From: Simon Davis <Simon.Davis@arun.gov.uk>
Sent: 10 December 2020 11:52
To: Planning.Responses <Planning.Responses@arun.gov.uk>
Subject: FW: AW/319/20/DOC- The Former Ship Inn Aldwick Street

Final Drainage Engineer comments

Client
Surplus Property Investments
Project
The Former Ship Inn, Aldwick Street, Bognor Regis. PO21 3AP
Title
Site Location and Block Plan

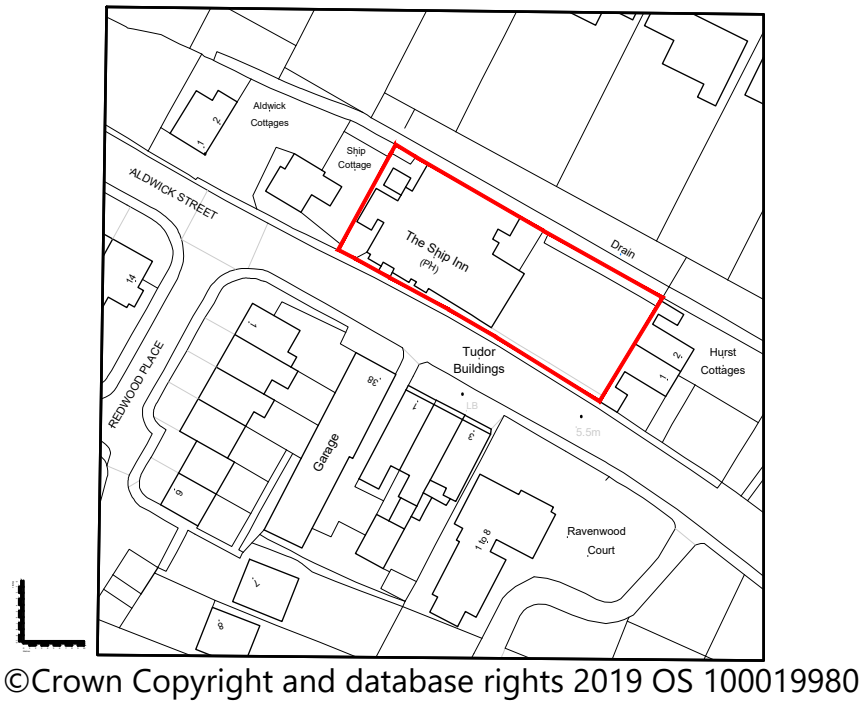
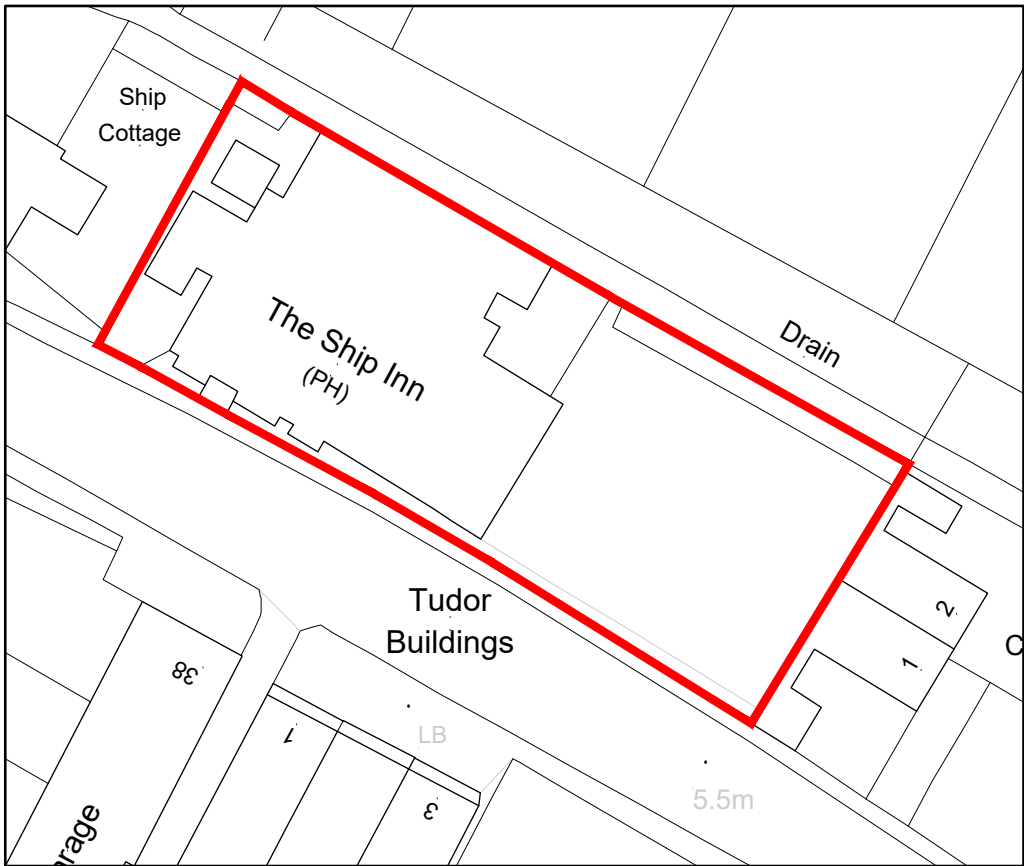
As discussed the proposals set out in an email and discussed on site should be okay. Could you please provide an updated plan with notes reflecting these proposals.

- As a minimum I would suggest there needs to be a headwall constructed around the piped outlet to the ditch, this should be in accordance with WSCC/ ADC standard details.

- There is some vegetation and debris within the watercourse. This requires clearance. We strongly recommend this is completed prior to the new fenceline being constructed.

- The furthest downstream buttress appears to have separated to some extent from the ditch retaining wall. This should be investigated as a priority and any necessary remedial works completed to ensure the stability of the wall.

In regard to the fencing to the drainage ditch at the rear of the site, you have the plan which indicates the position and arrangement of the fencing at the site. This is unchanged. You also have details of the appearance, type and form of fencing with the application. Furthermore, there is my clarification email in regard to the arrangement of the fence, having a single removable post nearest to the lock area of the gate.

It is believed therefore that there is sufficient information for you to discharge the obligations of the discharge of condition application, relating to this topic. There is no requirement for any drawing modifications in this regard.
